TECHNICAL NOTE

LAND AT BURDELL ROAD, YAPTON, WEST SUSSEX RESIDENTIAL DEVELOPMENT

Client: Driftstone Homes Ltd
Reference: 6145

Date: July 2021

Drawing Status	FINAL		
Client	Driftstone Homes		
Project	Burndell Road, Yapton		
Drawing Title	Pedestrian Visibility Splays		
Scale	1:250	Date	July 21
Drawn By	SMO	Checked By	ALB
Drawing No.	2020-6145-005		Rev. C

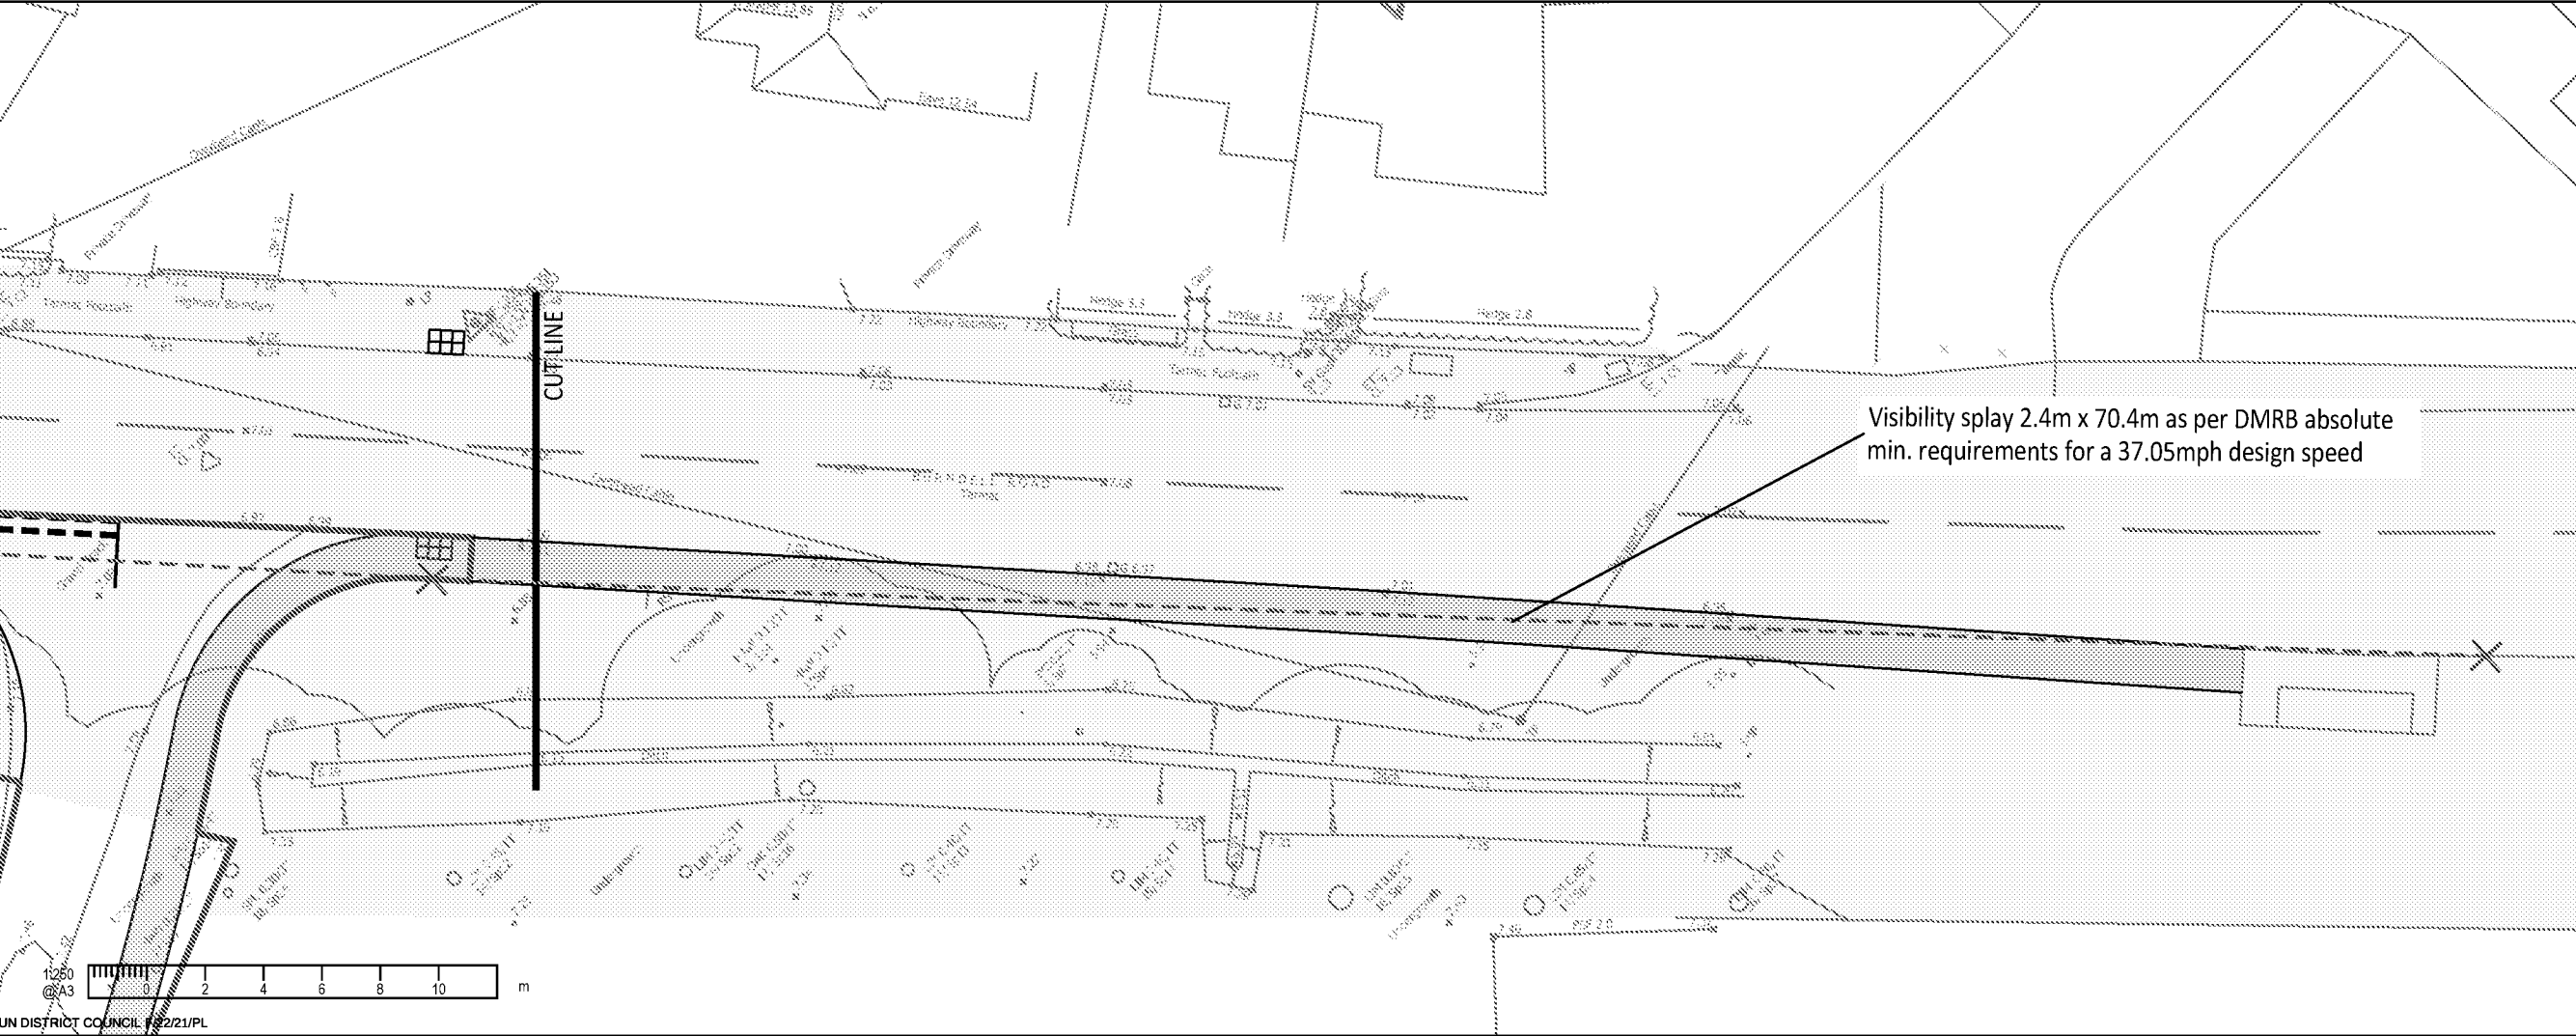
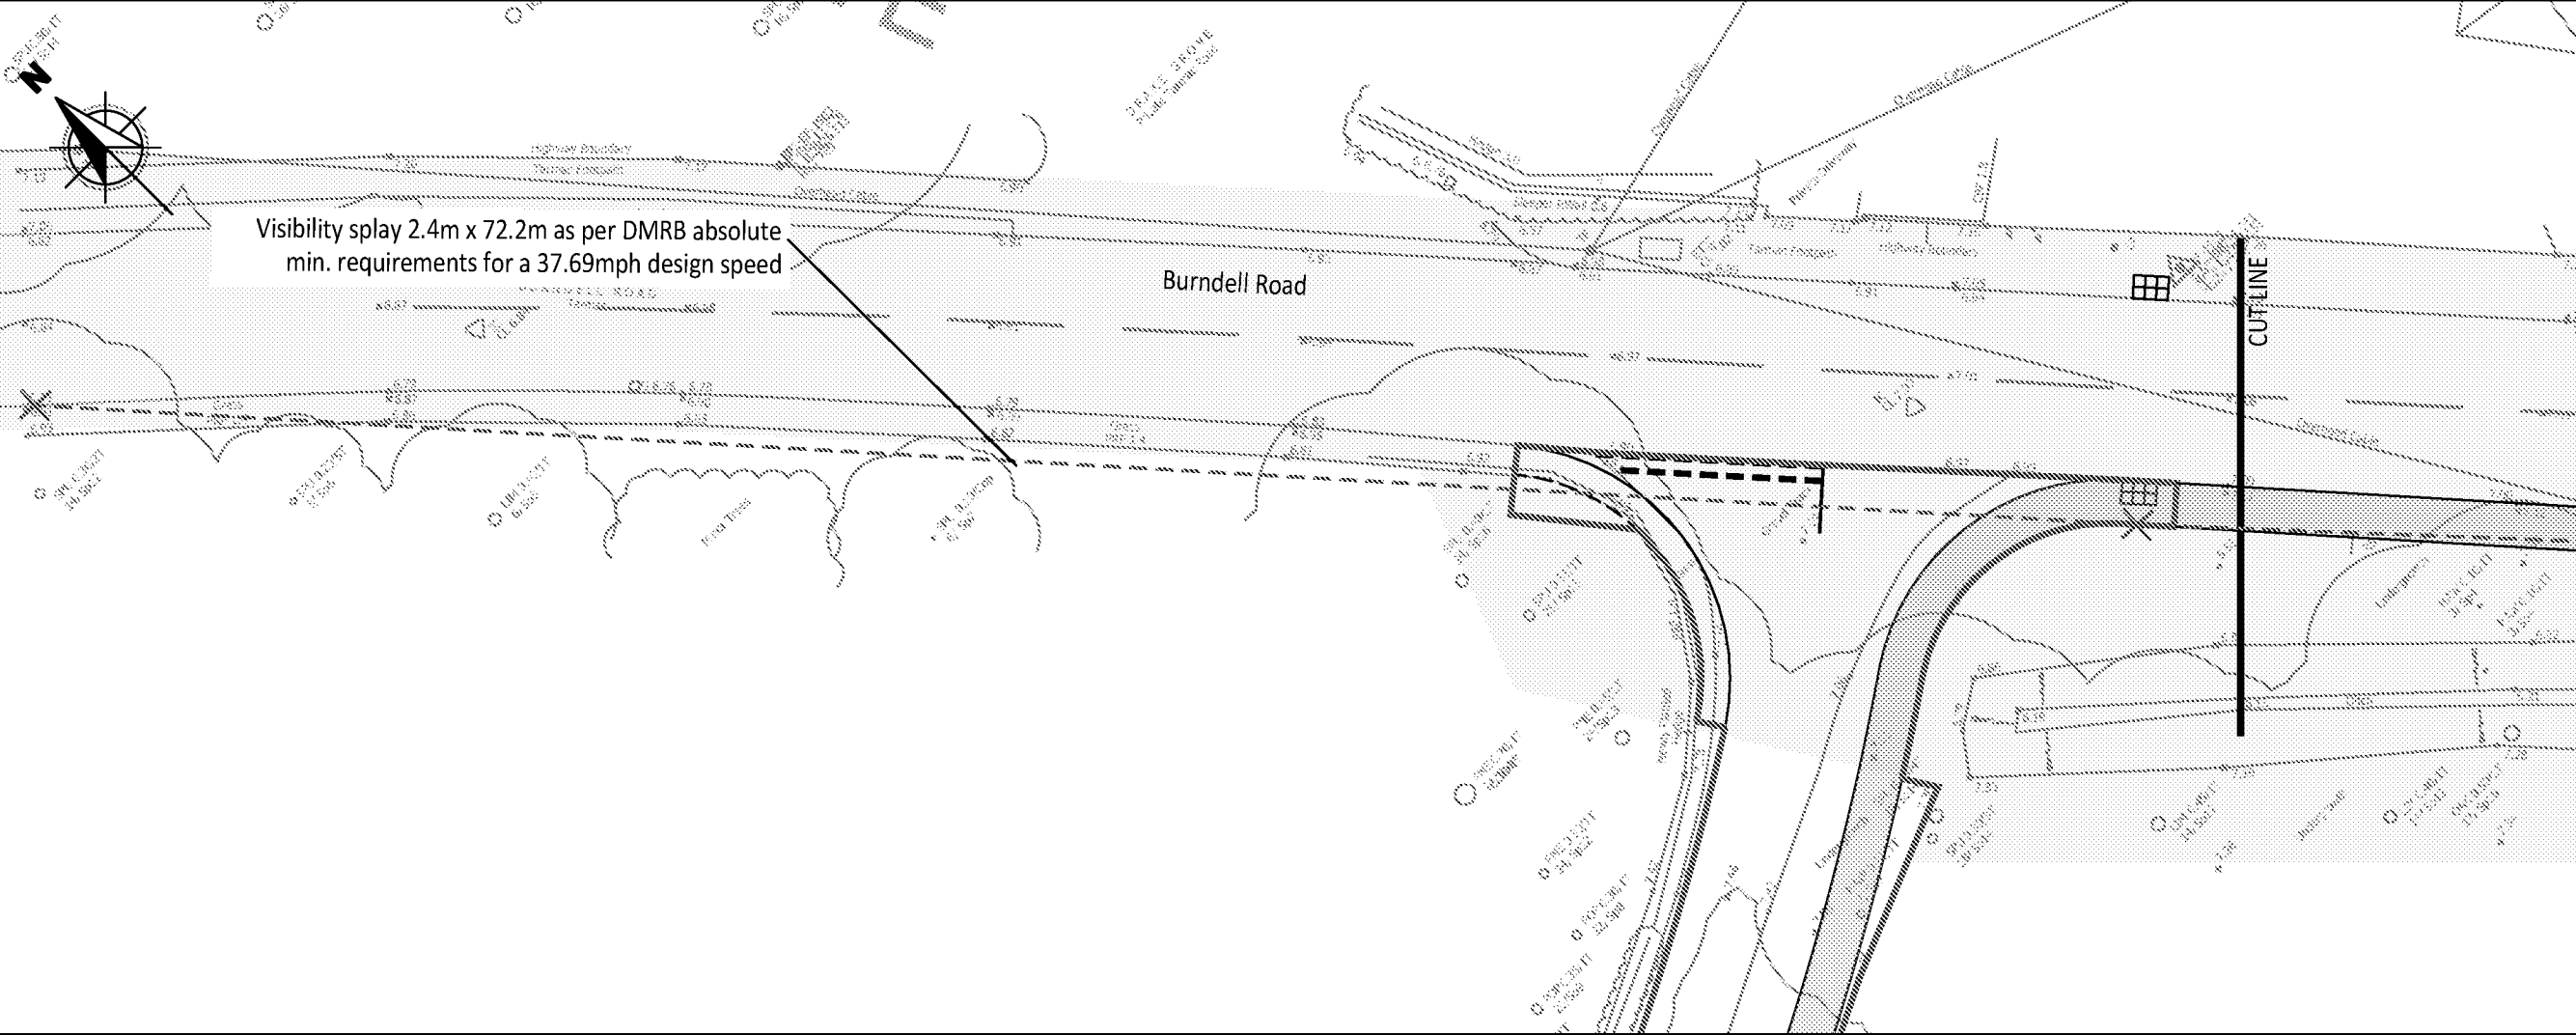
Location: B – Burndell Road south-east of the access junction (Dwg. 2020-6145-005 Rev. B)

Summary: Risk of pedestrian trips, falls and collisions with passing traffic.

The pedestrian visibility splays drawing shows that, 60m away from the proposed uncontrolled pedestrian crossing point on Burndell Road, there is a bus stop and shelter for north-westbound buses (photo 3).

It is more likely, however, that pedestrians will walk along the verge between the bus stop and the new development, risking trips and falls on the verge, or will walk in the carriageway when the verge is muddy, risking collisions with passing traffic.

- 2.2.4 Pedestrian visibility from crossings have also been demonstrated in accordance with the recorded 85th percentile design speeds with sight lines calculated using DMRB absolute minimum coefficients in **Drawing 2020-6145-005**.

- 2.3.2 An alternative betterment to the local footway network would however be offered in the form of a new footway to tie in with the 'Rollaston Park' bus stop to the southeast of the site. This additional infrastructure has been provided in accordance with the Stage 1 RSA recommendations.

The footway on the south-east shoulder of the development should be extended 60m to the existing north-westbound bus stop. This will also help safeguard the visibility splay south-eastwards from the development access junction (see problem 2.1 above).
